**Addendum No. 1**

RE: Contract ID: C202913  
WBS# 1CR.10081.19, etc.

**Bertie, Hertford and Northampton Counties**

**January 17, 2012 Letting**

PROJECT NO.	SHEET NO.	TOTAL NO.
1CR.10081.19, ETC.	24	25

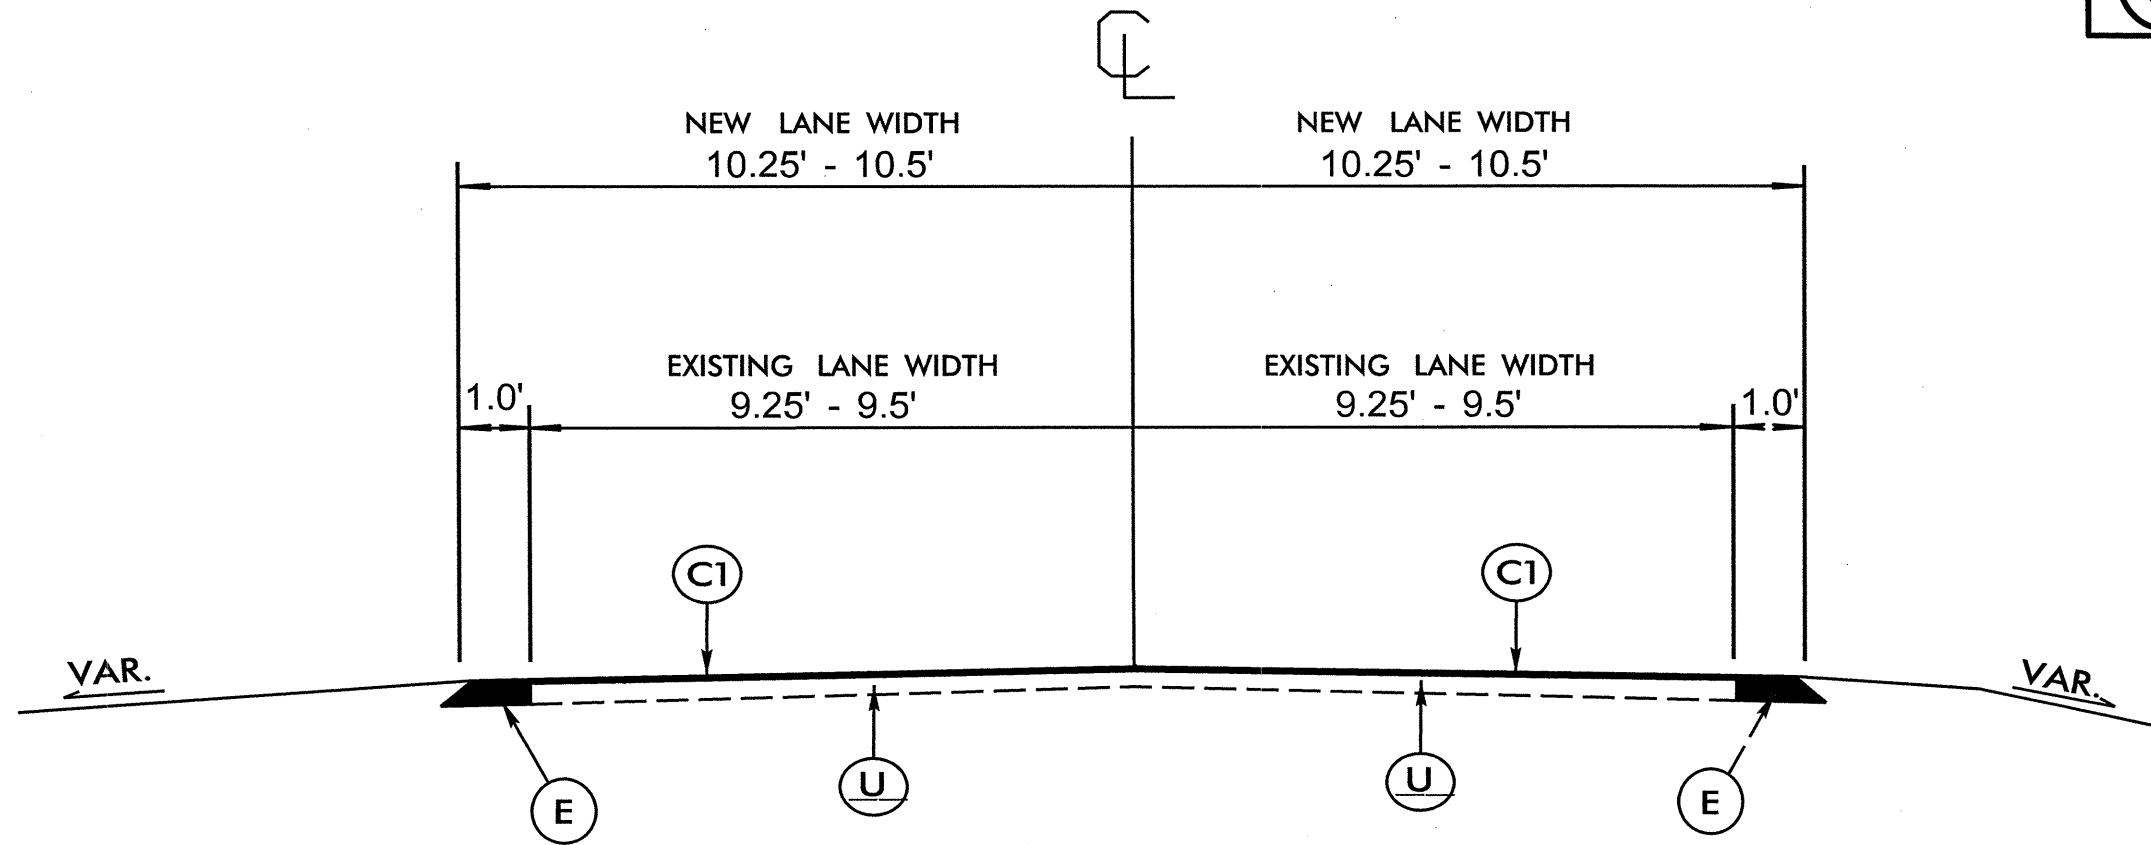
On Sheet No. 23 some corrections were made to the symbols for ACSC Type SF 9.5A. Please void Sheet No. 23 in your sketch maps and staple the revised Sheet No. 23 thereto.
